**HAZOP STUDY REPORT,
SITE A, SECOND COMBUSTOR,
QUANTEM,
PORT BOTANY, NSW**

28 October 2020

Pinnacle Risk Management Pty Limited
ABN 83 098 666 703

Quantem propose to install an additional combustor at Site A and requested that Dean Shewring from Pinnacle Risk Management chair the required HAZOP study. This report details the results of the HAZOP study in accordance with the requirements of the Department of Planning's HAZOP Guidelines.

Figure 3 – Second Combustor Schematic

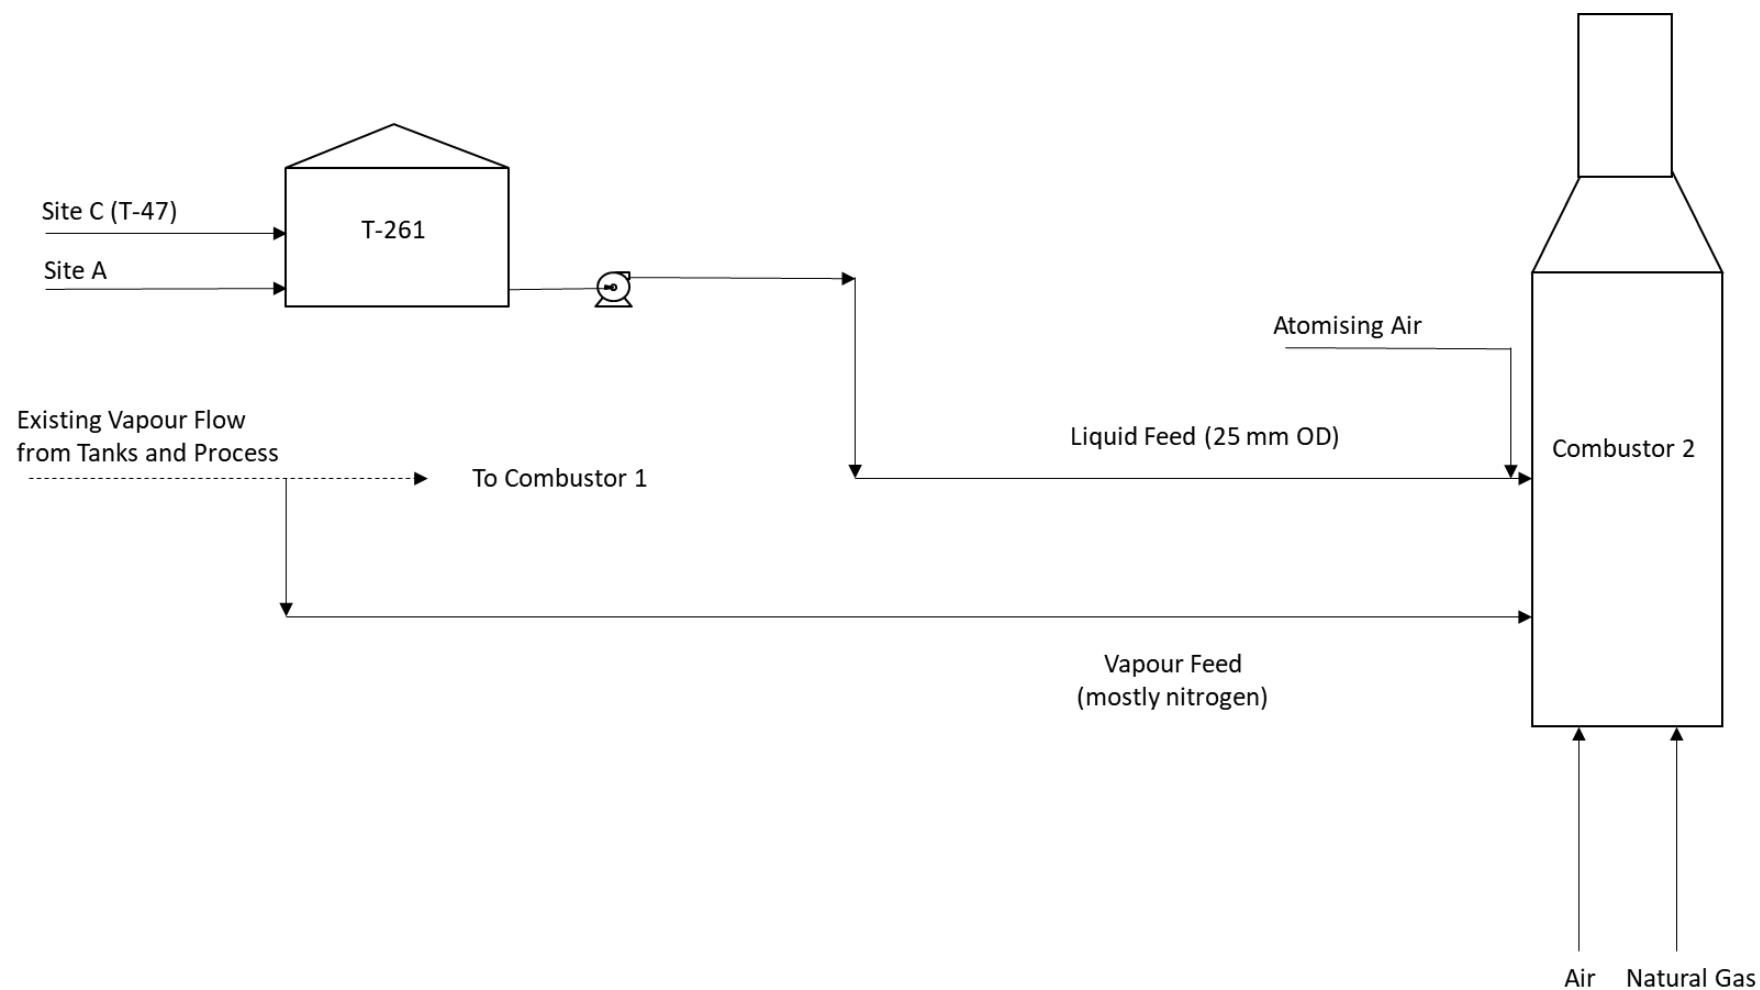
Node #	Node/Step								
1	Deviation/ Guideword	Causes	Consequences	Safeguards	Risk	Act #	Actions	Action By	Close-out Status
1.01	High level	Potential for high level in the vapour buffer tank T-41, e.g. due to long term liquid accumulation	High level in this tank will result in reduced residence time in the vapour piping system to the combustors and hence the potential for a flammable vapour stream to flow to the combustors prior to the oxygen trip analysers shutting down the combustors. This can lead to internal explosions within the vapour piping system due to flashback from the combustors	Historically, only small quantities of liquid are present in the vapour stream		5	1. Provide high level protection for T41 2. Include in the procedures the requirement for draining of the low point drains in the vapour piping system and T-41 as appropriate	1. FS 2. SB

1.02	Change in concentration	Potential for oxygen to be introduced to the combustor feed vapour line when draining low points and/or T-41	Potential for flashback from the combustors and internal pipe explosions	Detonation arrestors with high temperature trips on the inlet to the combustor		6	Include in the PMs the need for routine inspection of all low point drain non-return valves	WJ

1.03	Design issue					7	Include in the detail design for the new combustor the ability to achieve and prove the 1 second residence time as per the EPA licence	FS

1.04	Reverse flow	Both combustors (thermal oxidisers - TO's) online and no forward flow occurs from the tanks	Potential for reverse flow from one TO to the other TO due to the chimney effect. This will introduce oxygen and hot gases into the system, i.e. explosion and equipment damage risks, respectively	High temperature trips on the detonation arrestors will close the double block valves. NRV's 260/270		8	Install an isolation valve upstream of both NRV-260 and NRV-270, i.e. to allow maintenance checks on the NRVs. The valve type is to be determined. Alternatively, review the option of relocating the NRV's to immediately upstream of the detonation arrestors so that the double block valves can be used for maintenance	FS

1.05	Impurities	If one TO is offline for a significant period of time then there is potential for air ingress into the vapour feedline to the double block valves	Potential for internal pipe explosion during combustor startup	Detonation arrestor located on the TO inlet nozzle. Short length of line minimises the volume of gas		9	Review the need for a startup nitrogen purge for each of the TO's feedlines	FS

1.06	Change in concentration	Operating FN-40 at high speed	Potential to exceed the design residence time through T41 and 33 and hence oxygen flowing to the TO's. This can lead to internal explosions within the vapour piping system due to flashback from the combustors	Operator response to FAH-302		10	Provide means to limit the flow to the TO's to ensure that the oxygen trip residence time requirement is met	FS

Node #									
2	Deviation/ Guideword	Causes	Consequences	Safeguards	Risk	Act #	Actions	Action By	Close-out Status
2.01	Design issue					11	Mark up the P&ID to show XV-001 as fail closed. Apply this action to all actuated valves in the modified piping systems	FS

2.10	Zero flow	T261-XV-001 closes during transfer	Potential for hammer in the transfer pipeline which may lead to piping damage			19	T261-XV-001 is to be a slow closing valve to avoid hammer	FS

4.06	High pressure	T261-XV-002 closed	Potential for thermal overpressure when the trapped upstream liquid is heated by the sun and hence a loss of containment				Provide thermal relief around T261-XV-002	FS

4.07	High pressure	Potential for hammer when T261-XV-002 closes	Potential for piping system damage and hence a loss of containment				Ensure valve T261-XV-002 is slow closing	FS

5.03	High flow	P-02 stops	Potential to syphon from T261 to TO2	Backpressure regulator PCV-114 set point is above tank head. XC-815, XV-816 and T261-XV-003 will be closed by the control system when P-02 stops			No further action required

5.07	Plant items					36	Provide a locked open isolation valve on the outlet of PRV-115 to allow maintenance	FS

6.02	Zero flow	Loss of compressed air due to V-388 closed, PCV-382 fails closed, V-380 closed and/or XV-817 closing	Loss of atomising air flow to the combustor, potential for liquid jet fire/pool fire and hence damage to the combustor	Procedural controls to keep the in-line manual valves open, operator response to low flow and low pressure alarms, low flow combustor trip, limit switches on XV-817		38	Include in functional description a low pressure trip from PIT-393	FS
